Title:	Viewpoint 2: Lodge Lane South
--------	----------------------------------

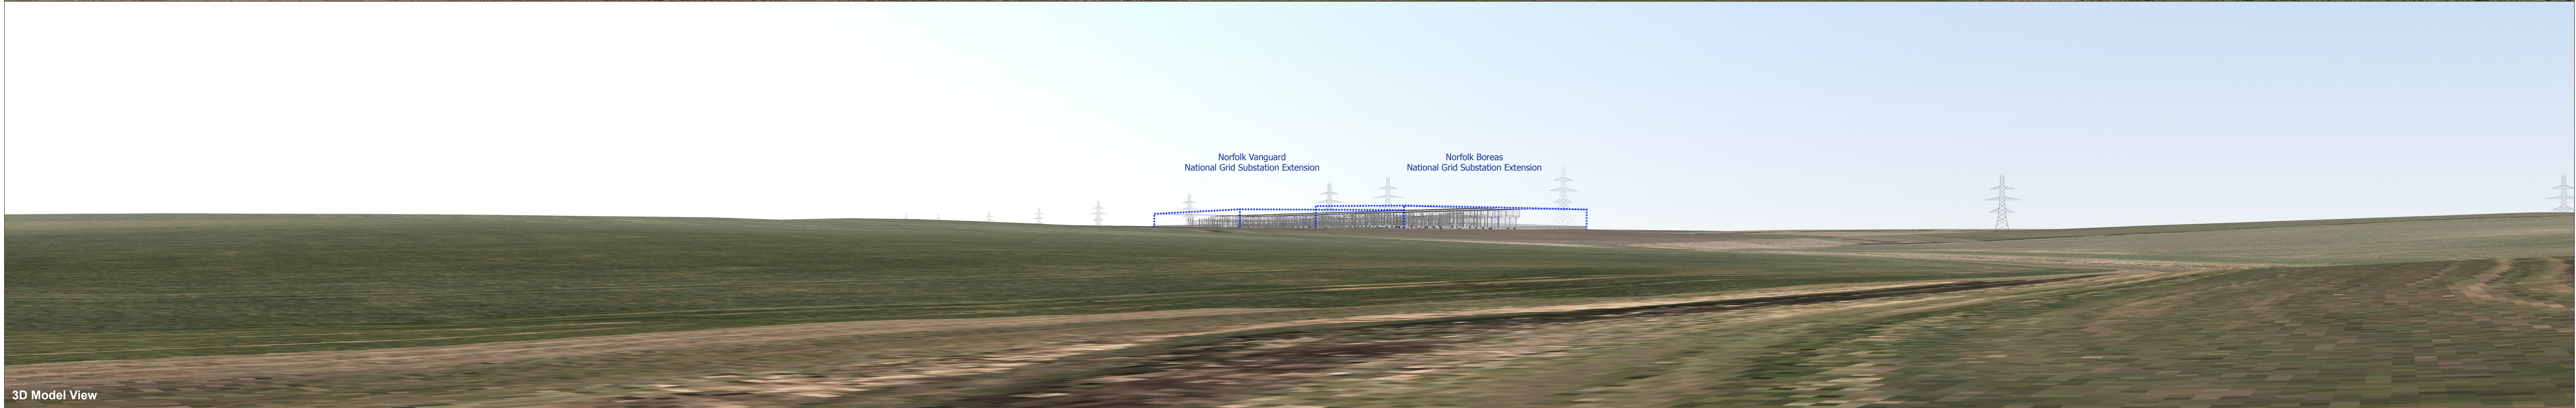
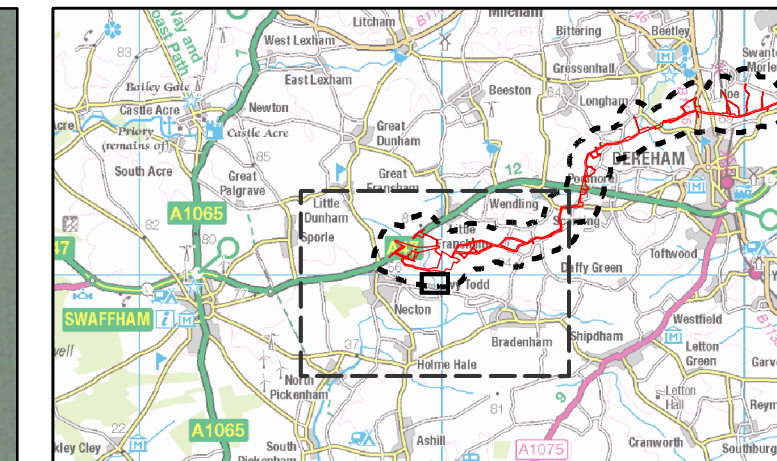
It has recently come to my attention that the applicant's photo montages at Lodge Lane North and South are flawed. I have lived on my farm [REDACTED] for 50 years, and family have owned Necton Farm since 1947 so we are all extremely familiar with the lay of the land. The applicant has said that they don't know whether the the rise in landform shown as being to the fore of the onshore project substation actually occurs or not, and it cannot be determined from the baseline photograph, as the mature woodland associated with Lodge Farm screens this portion of the view. Using Google Earth Pro, ground levels through Lodge Farm trees shows that the land continues to gently fall to the west, away from the lane, as it does all the the way along the lane, up to Lodge Farm. I have also walked the area and I can confirm this, with no concealed ridgeline. I disagree with the applicants opinion, that the more critical point in terms of screening is the extent to which the landform falls away to the south. I agree the land falls approximately 5m from Lodge Farm to the viewpoint, but the land continues to rise a further 3m beyond Lodge Farm, to the converter halls. With the comparable distance from the viewpoint to Lodge Farm, and from lodge farm to the converter halls, the further 3m rise behind Lodge Farm negates most of this critical screening effect, and yet the photo montages show the converter halls with a 17-18m screening effect. I have included a scale side elevation diagram of viewpoint 3 to demonstrate the situation, and it shows the converter halls in full view. As the ground continues to fall at a similar gradient to Lodge Lane South viewpoint 2, from viewpoint 3, the same issue applies, and the converter halls will be far more visible than shown in the montage.

Title:  
Viewpoint 3:  
Lodge Lane North

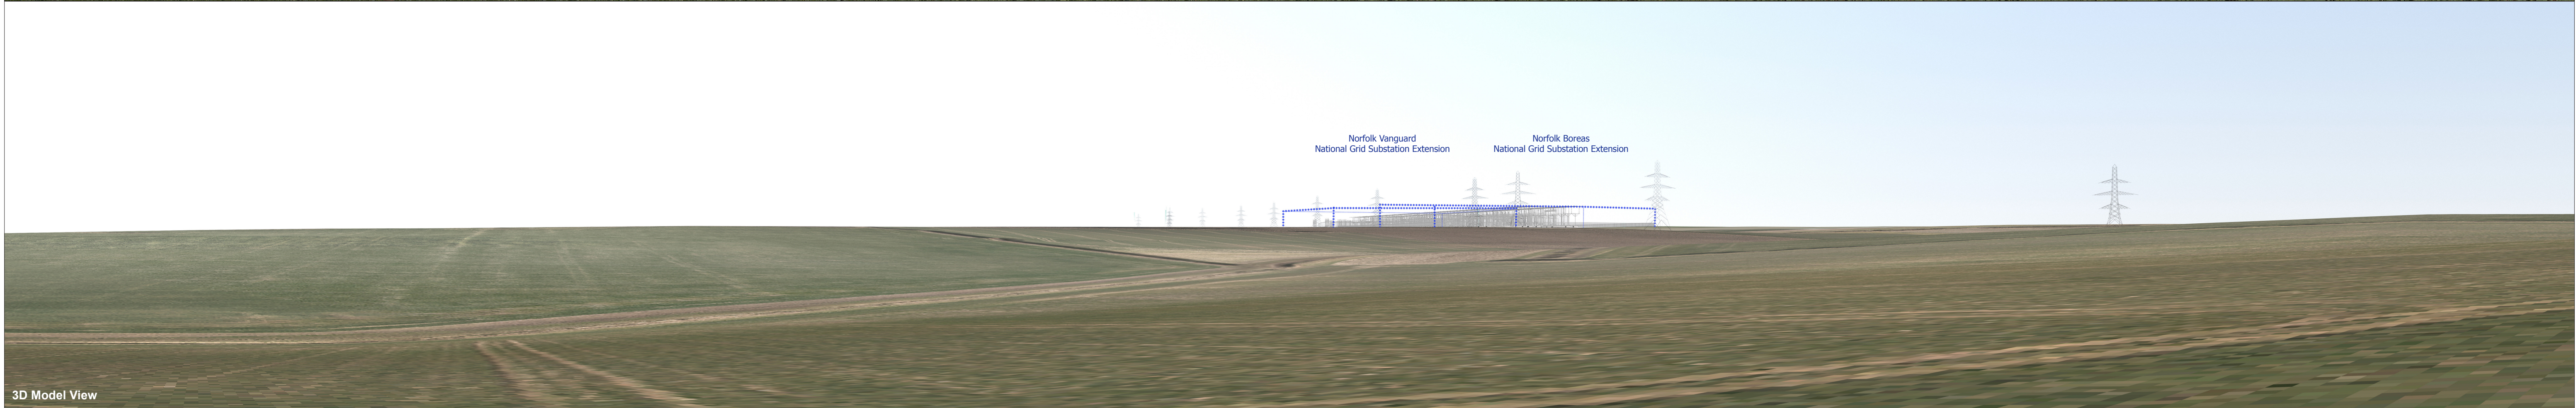
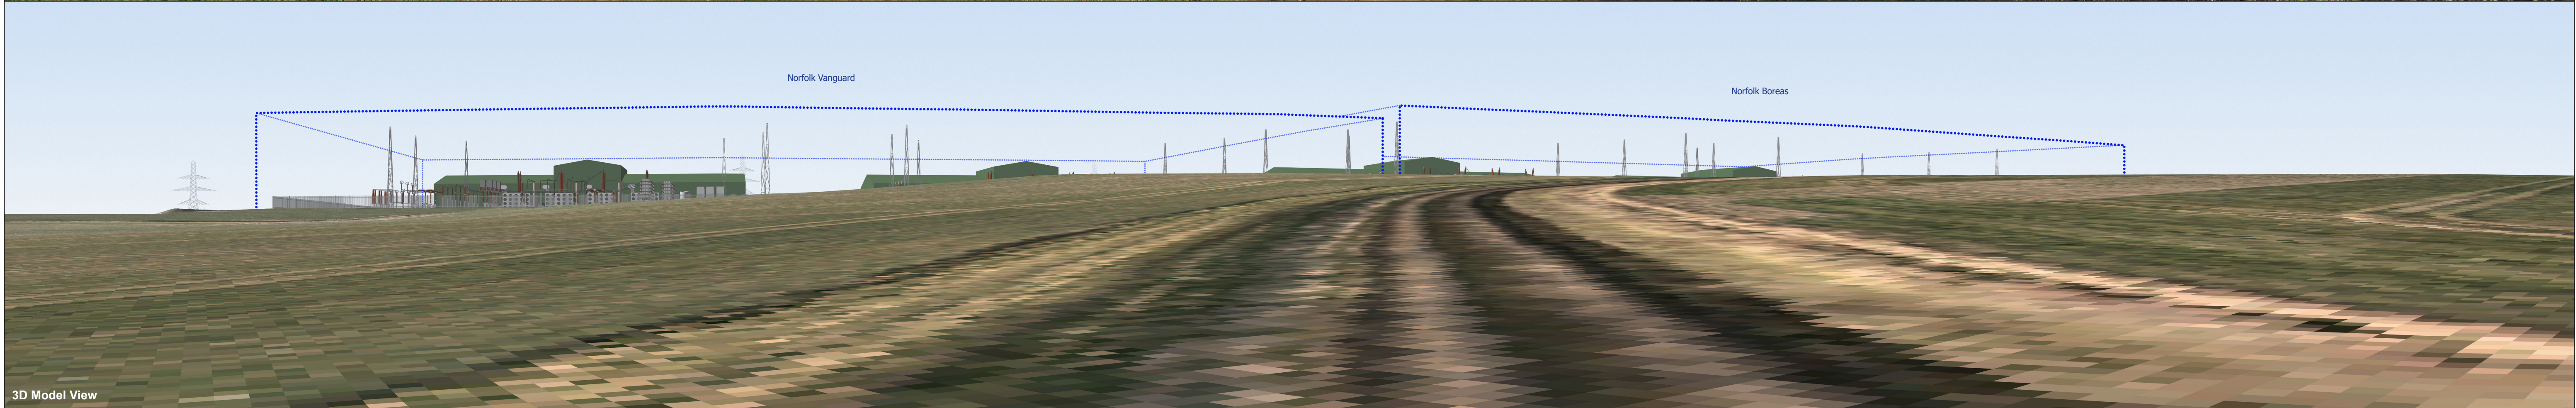
On 23rd January 2020 I attended an accompanied site visit with the Boreas Planning Inspectors. I was able to show them the errors produced by the applicant's software and demonstrate at the sites that there was no ridges where they are shown on the photomontages at Viewpoint 7. Unfortunately Viewpoint 3 was not included in this Accompanied Inspection. This is because the applicant has been misleading residents during both consultations to believe that they were concerned by private individual's views, whereas at the inspection they gave me the impression that they are really only concerned with public viewpoints. If we had known how things stood we would have requested a site visit to Lodge Lane. We would also have asked for a visit to Ivy Todd Road and Chapel Lane, where the substations would be seen from the public highway.
